**From:** Planning Appeals  
**Sent:** 10 September 2021 16:02  
**To:** north2@planninginspectorate.gov.uk  
**Subject:** RE: Planning Inspectorate APP/R5510/D/21/3281302: 41 Tollgate Drive, UB4 0NP  
**Attachments:** Plans - 67932-APP-2011-1729\_.pdf

The Council have the following comments to make on the revised statement –

Proposed Ground Floor Plan

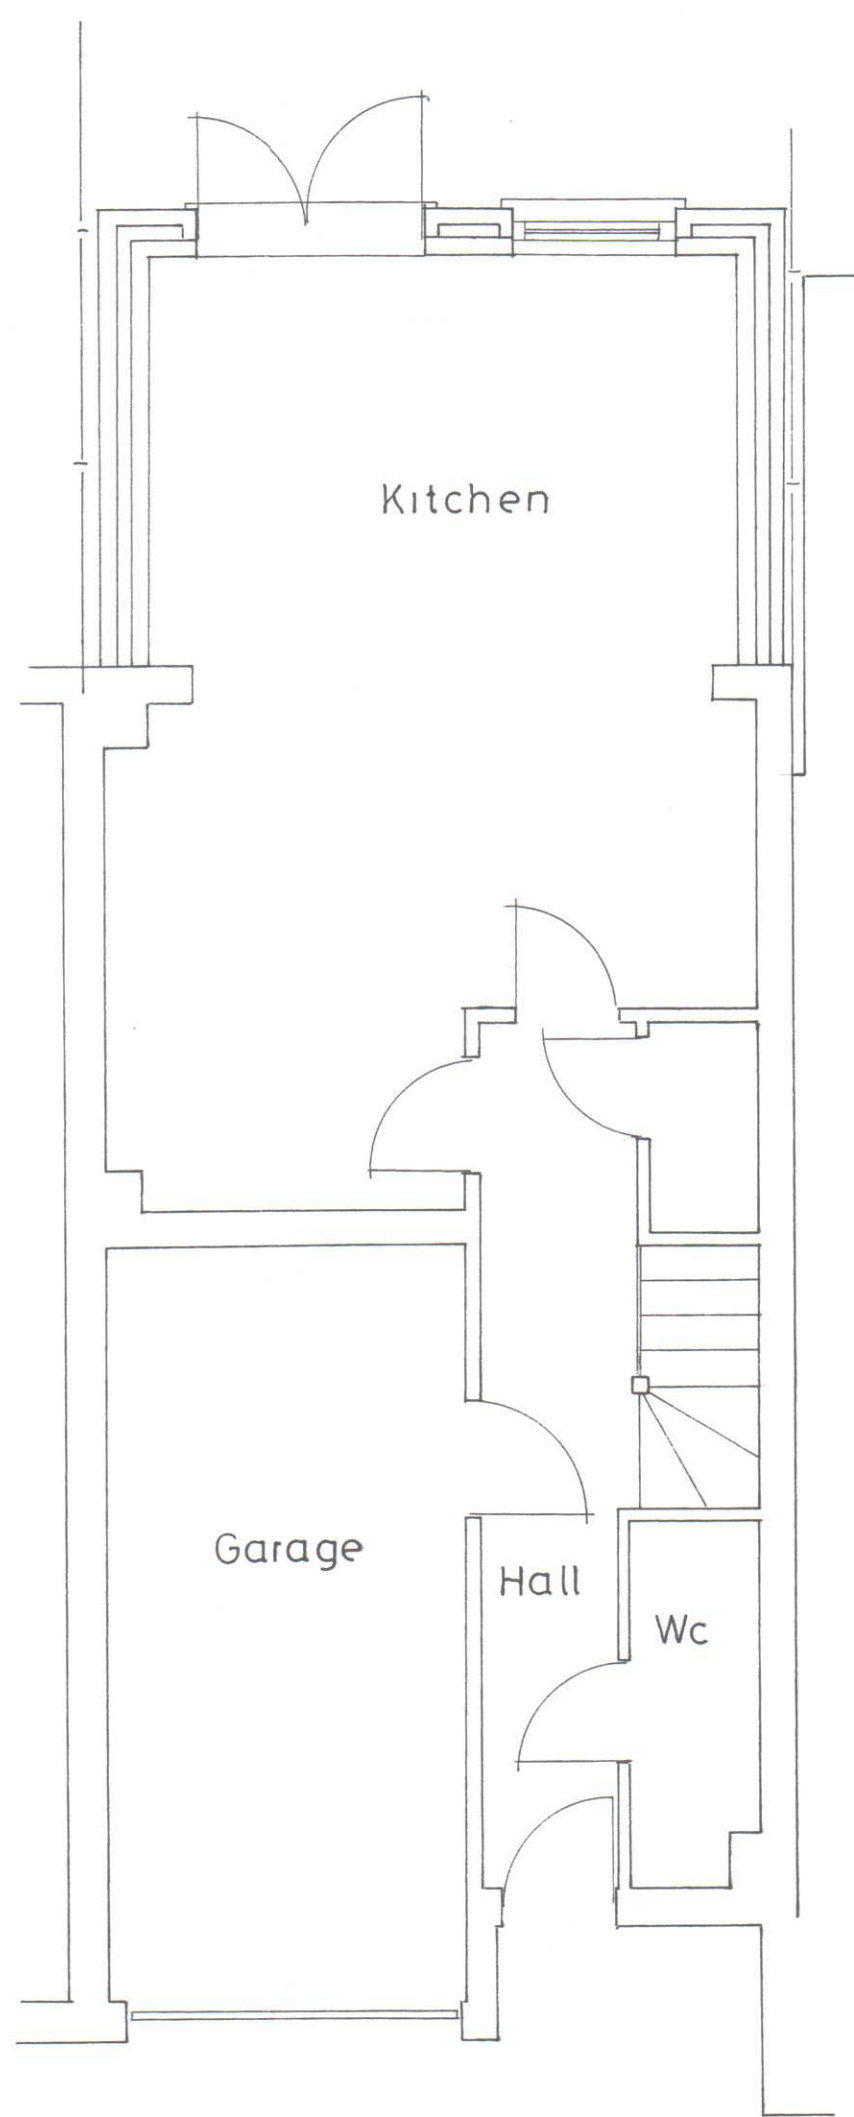
**(1) Following development, the application site would only provide 40 square metres of private amenity space to occupiers. This is deemed unacceptable for a Four bedroom dwelling, especially if you consider the fact the proposed ground floor utility study area could be converted into a fifth bedroom.**

**(2) The appellant's appeal statement states '*LPA have, in July 2011, granted an identical rear extension under planning Ref: 67932/APP/2011/1729.*' This is not the case. Although the extension would be identical in terms of the dimensions, the internal layout of the proposals vary greatly. The 67932/APP/2011/1729 proposed plans (attached for your reference) indicate that there would be no bedrooms on the ground floor, whereas the application in question (67932/APP/2021/2437) would provide two. The presence of the additional bedrooms therefore means an increased provision of private amenity space is required as per Policy DMHB 18 of the Hillingdon Local Plan: Part Two - Development Management Policies (2020).**
